SF2017/201122; WST17/00132/03

**SSD 8696; Lots 1, 2 and 3 DP 506925, Lot 122 DP 753238 and Lot 90 DP 657805  
Suntop Road, Suntop; Suntop Solar Farm**

**Roads and Maritime Services**

Figure A 28: Basic right (BAR) turn treatment on a two-lane rural road

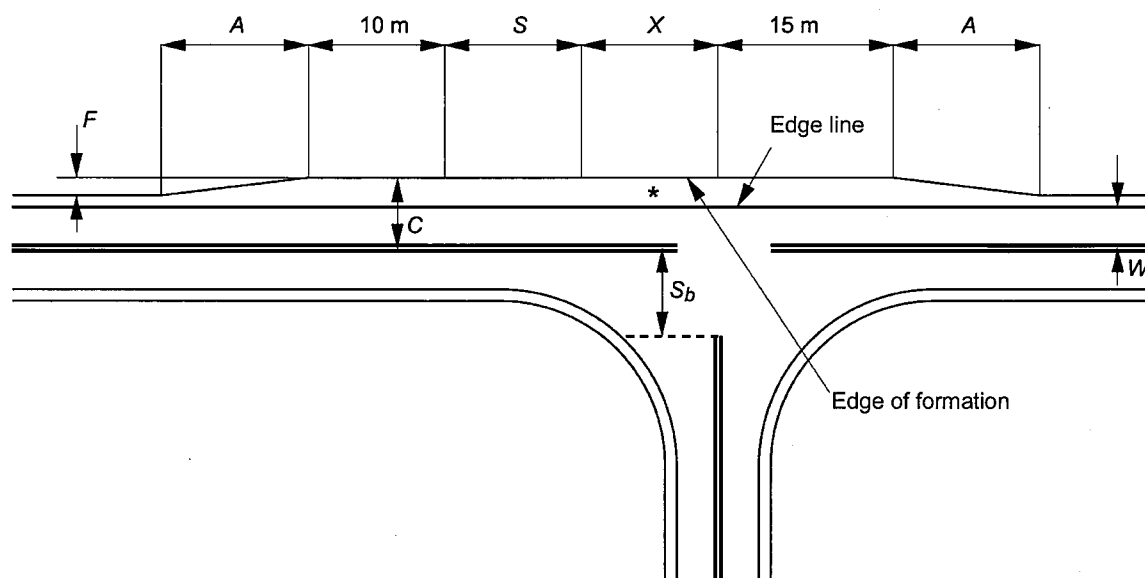
- Prior to the commencement of construction work, a Basic Right (BAR) turn treatment in accordance with Figure A28 Part 4 of *Austroads Guide to Road Design* (copy enclosed), is to be provided in Renshaw McGirr Way at its intersection with Suntop Road. The intersection works are to be designed and constructed for a 100km/h speed environment and be able to accommodate the largest vehicle accessing the intersection.

Figure 8.2: Rural basic left-turn treatment (BAL)

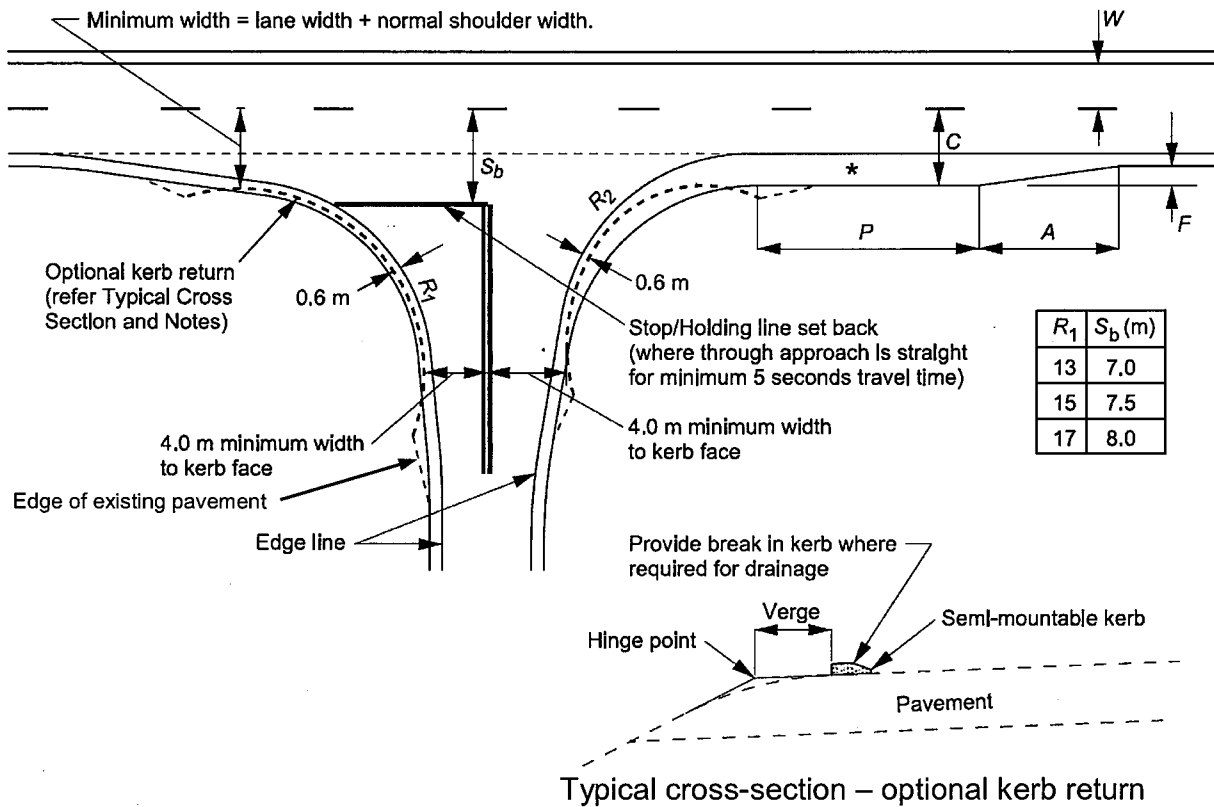
- Prior to the commencement of construction work, a Basic Left (BAL) turn treatment as shown in Figure 8.2 Part 4A of the *Austroads Guide to Road Design* (copy enclosed) is to be provided at the intersection of Renshaw McGirr Way and Suntop Road. The BAL facility will also need to be sealed and built for a 100km/h environment.
